Application: 22/01785/PLF

Proposal: Conversion of existing agricultural building to two dwellings

At: Newbreaks Farm, Kings Causeway, Adlingfleet, DN14 8DZ

Holding Comments – Recommendations made

PROPOSED GROUND FLOOR PLAN
 (As Proposed By Architect-Over marked with Structural Recommendations)
 (Scale 1:100)

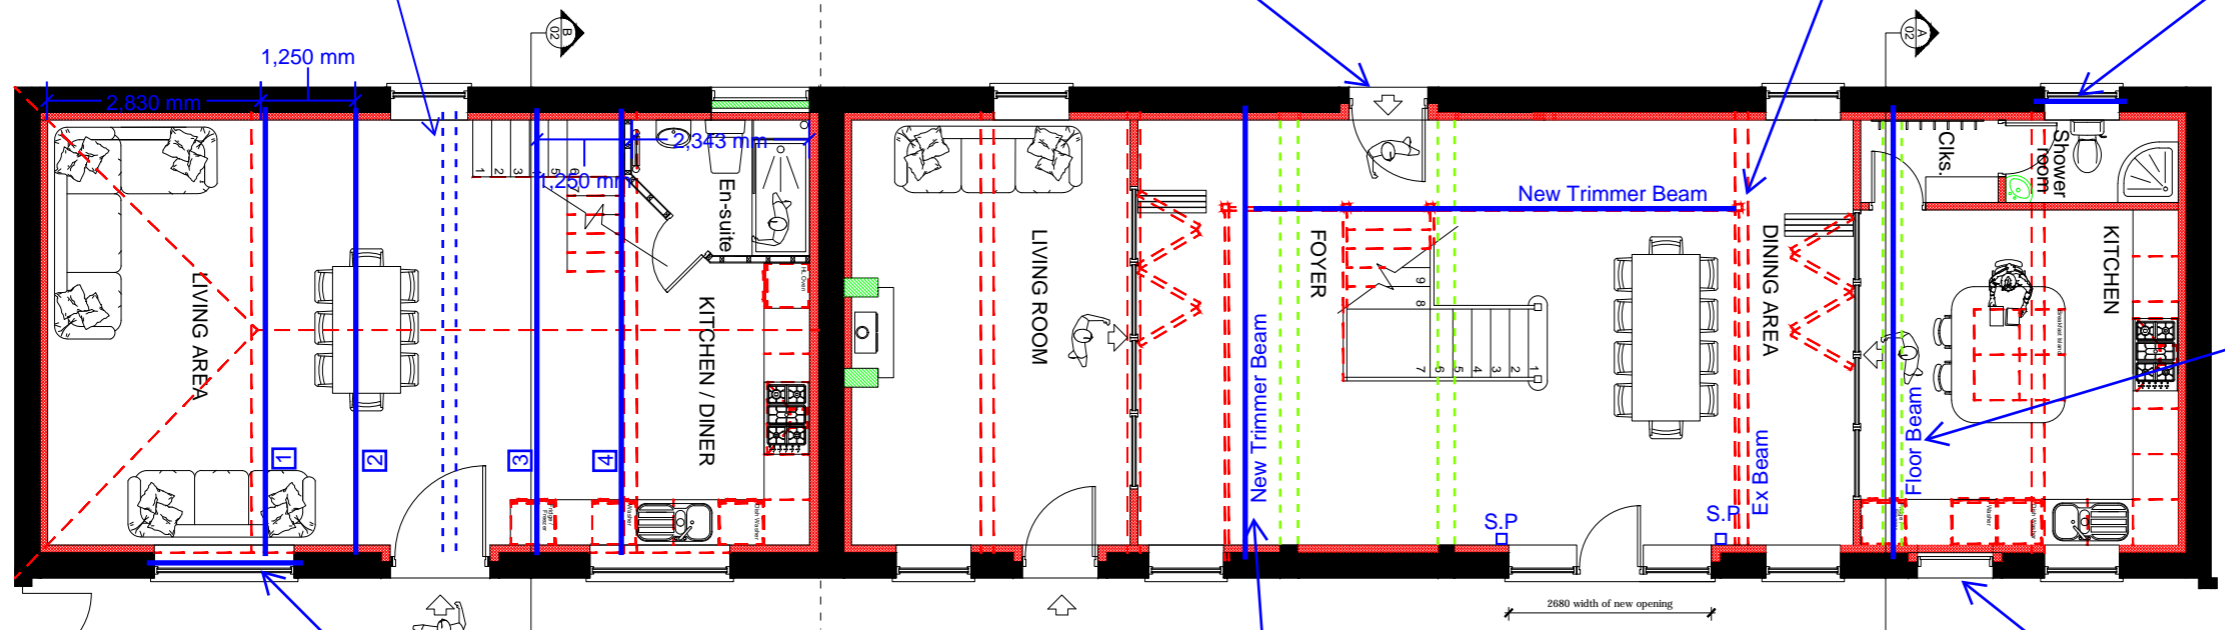
The submitted proposed floorplans show one scheme with a Mezzanine level on the south part of the building, however the submitted Structural Survey mentions two schemes, option 1 (submitted plans) proposing the mezzanine and option 2 without Mezzanine. To minimise the loss of any historic fabric and due to having concerns with practicality, we recommend Option 2 (scheme without mezzanine) as the most sympathetic proposal. We therefore need to see the formal submission of the proposed floor plans for option 2.

PROPOSED ROOF PLAN

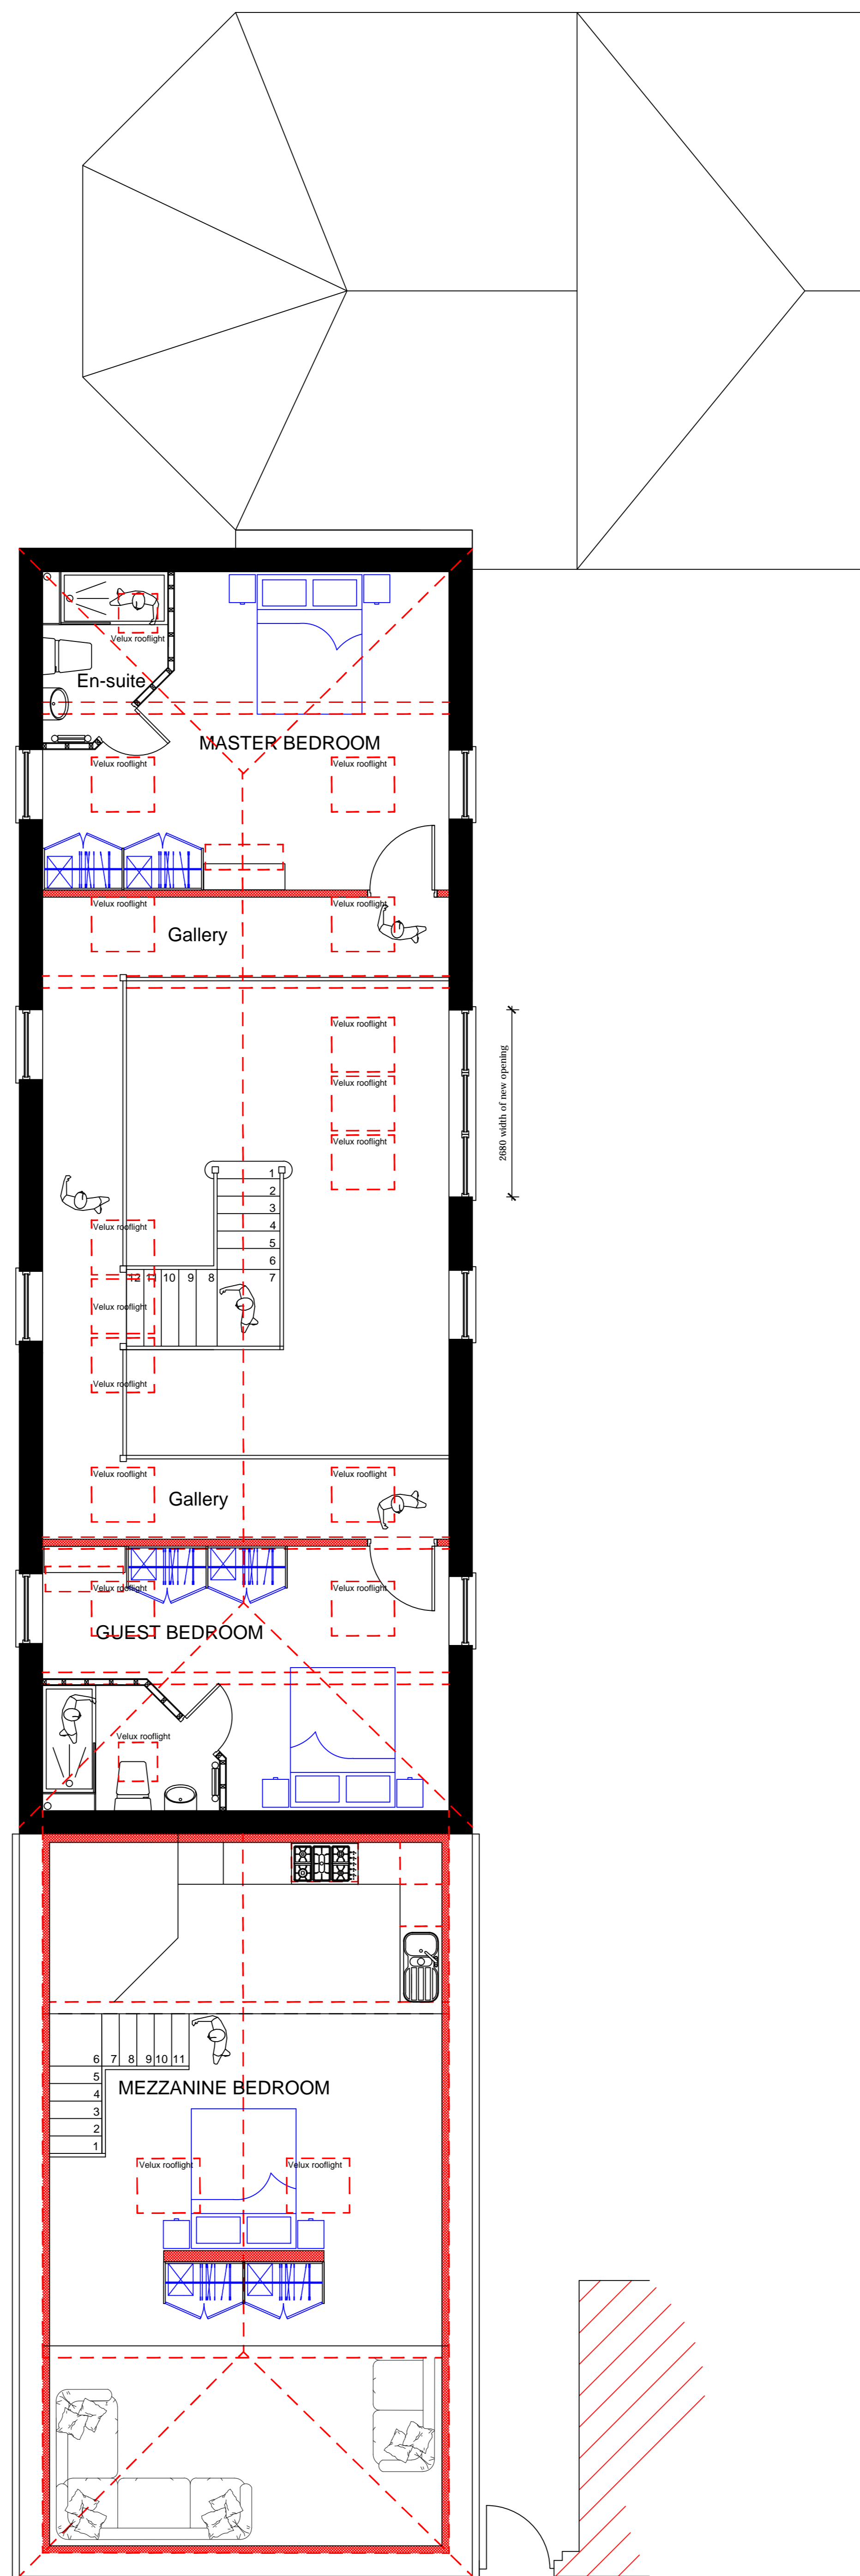
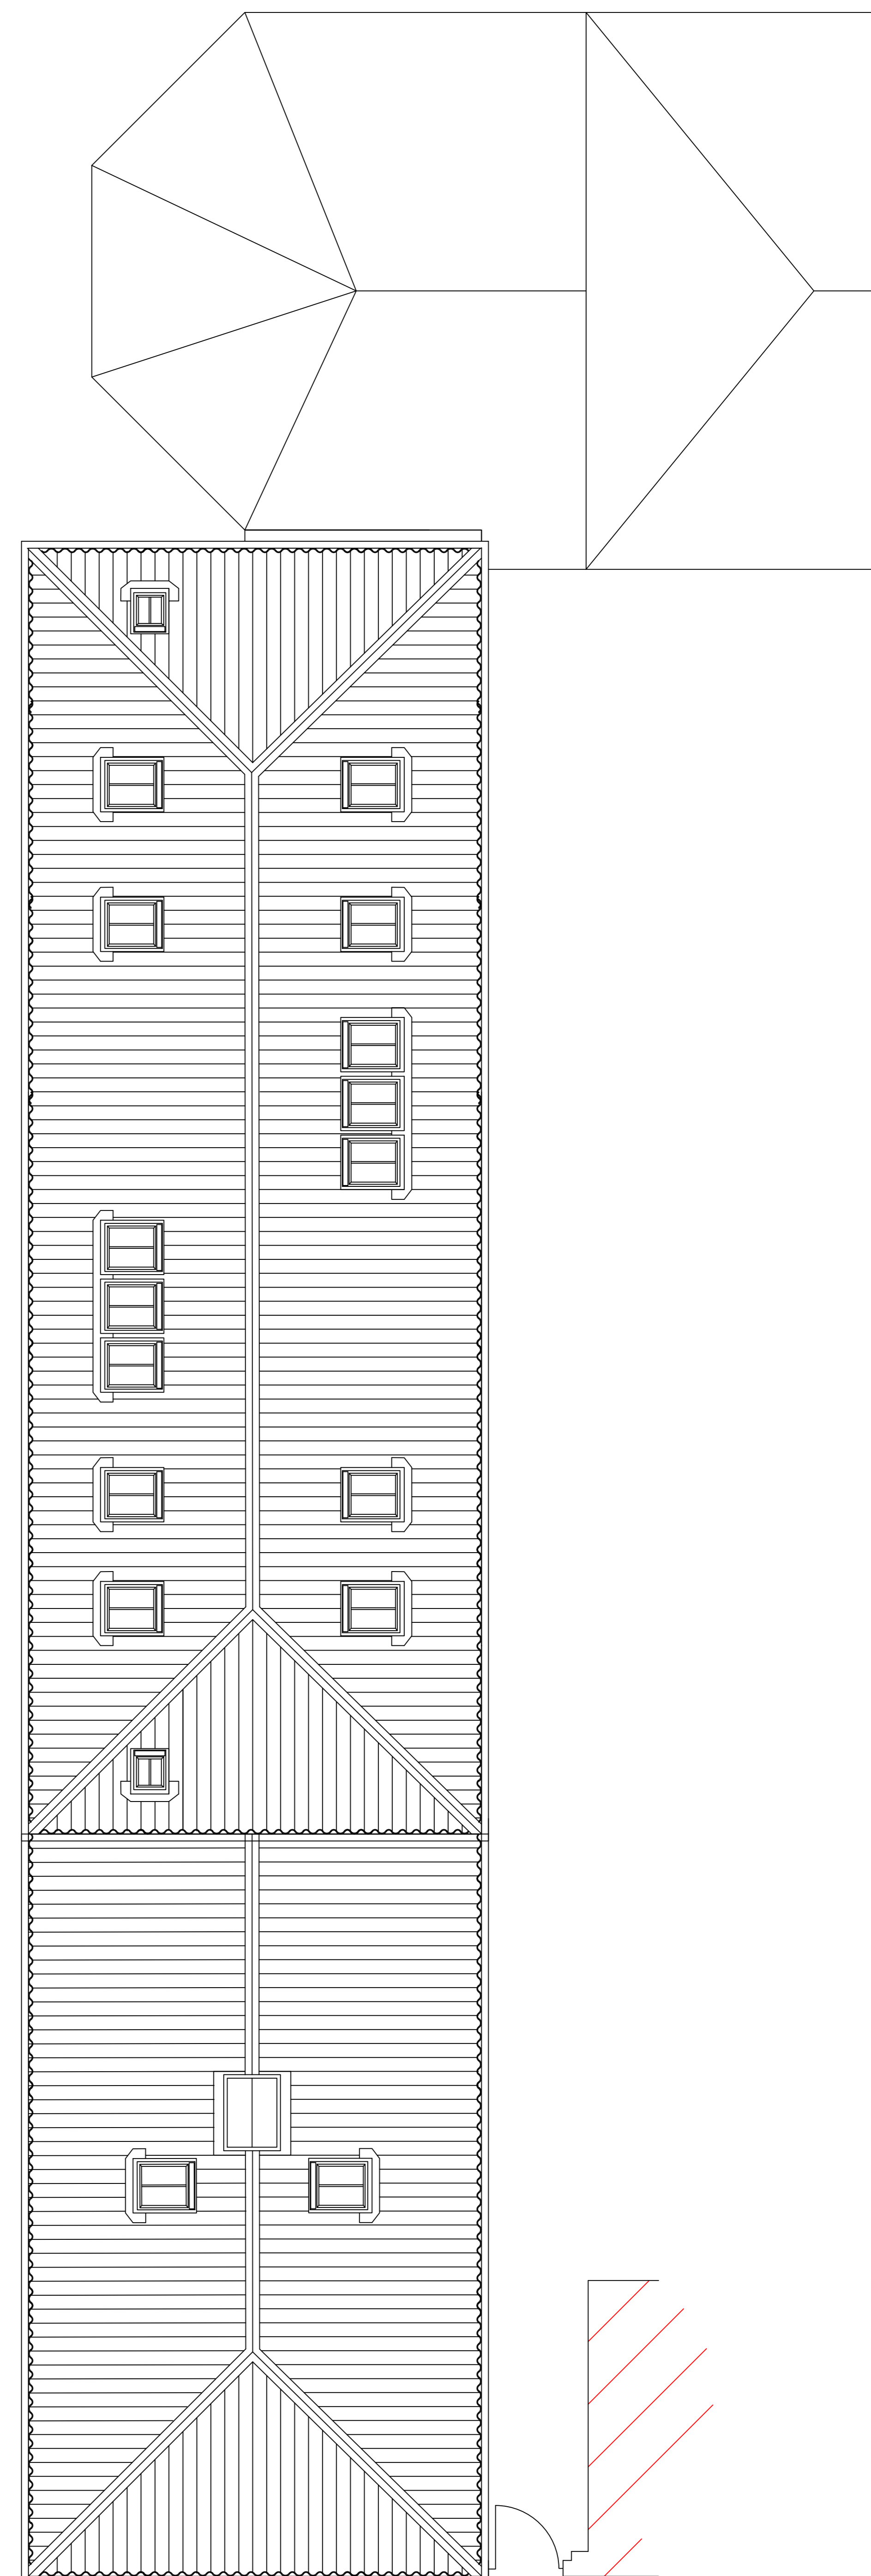
- The no.6 large rooflights (three on each roof elevation) are reduced in size to match other proposed rooflights and are reduced from three on each side to two. We recommend that any rooflights proposed are of heritage design featuring central glazing bar and are to be set within the roof slope, not protruding from, to minimise external impact.
- Underneath the arched windows on the left side of the east elevation it would be a more honest feature if the bottom half of the windows, where timber boarding is proposed, is left as exposed but recessed brick. This would allow future onlookers to view the architectural changes of the building more clearly.

PROPOSED EAST ELEVATION

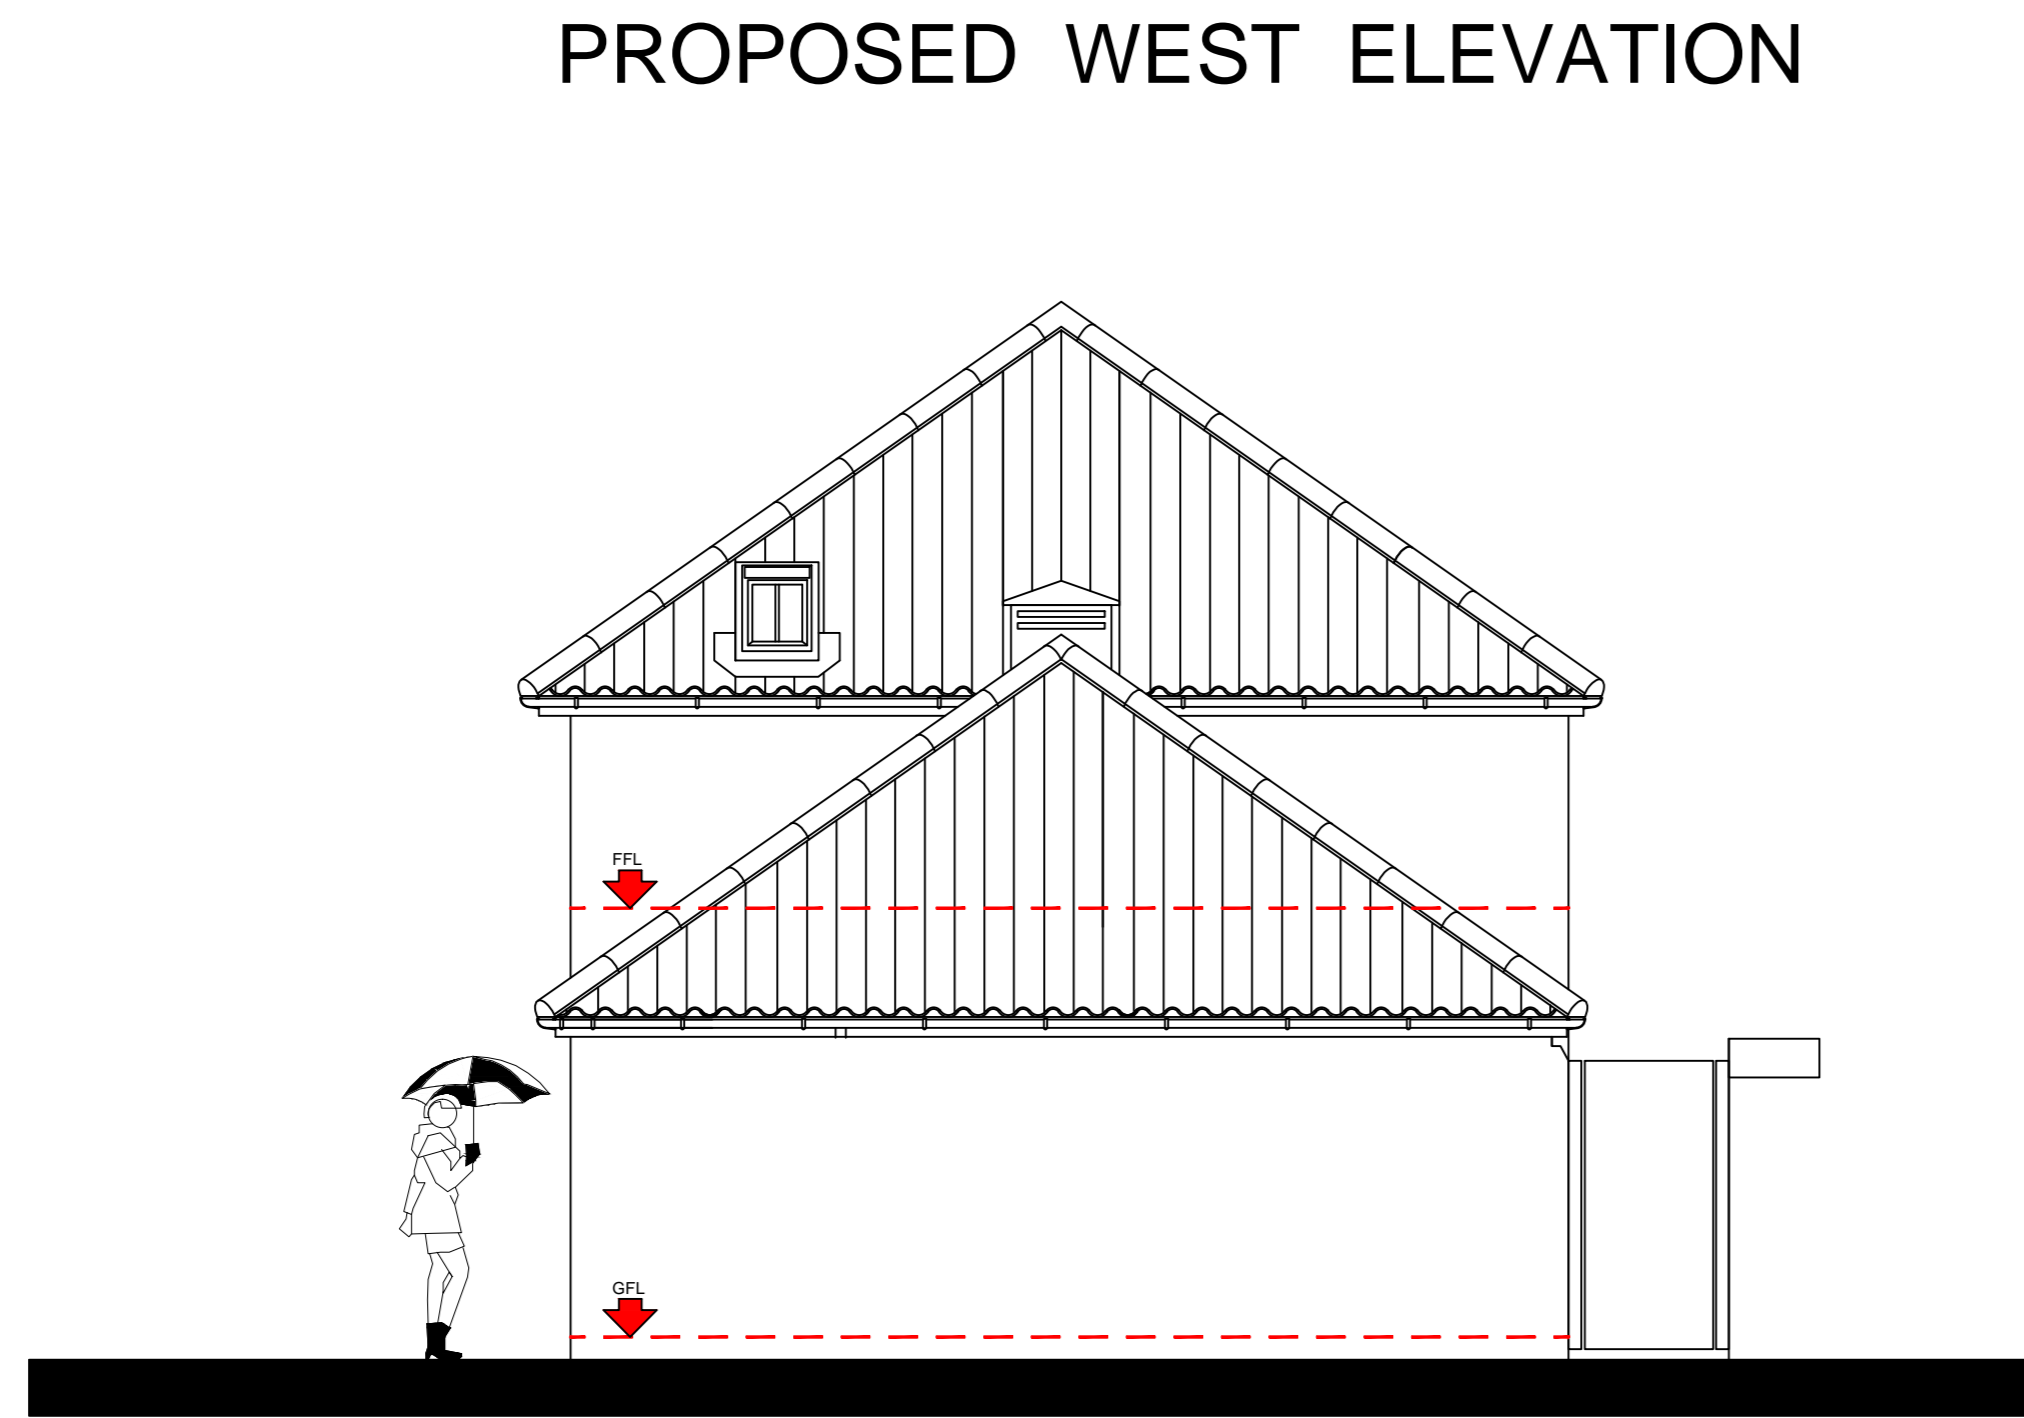
The main concerns we have with the external proposals is the large area of predominantly glazing on the right-hand side of the east elevation. Because of the extent of the glazing, this creates what appears to be a floor to ceiling glazed 'wall' which is carried up to the roof slope due to the three large, close knit rooflights. This proposed feature as a whole is not in keeping with the agricultural nature of the property, and whilst the conversion of this building is fully supported, we must also be conscious of maintaining the architectural and historical significance that the listing represents.

- Removal of the large area of glazing to the first floor outlined in orange below, and retention of existing window opening (see green outline) to break up the 'glazed wall' effect
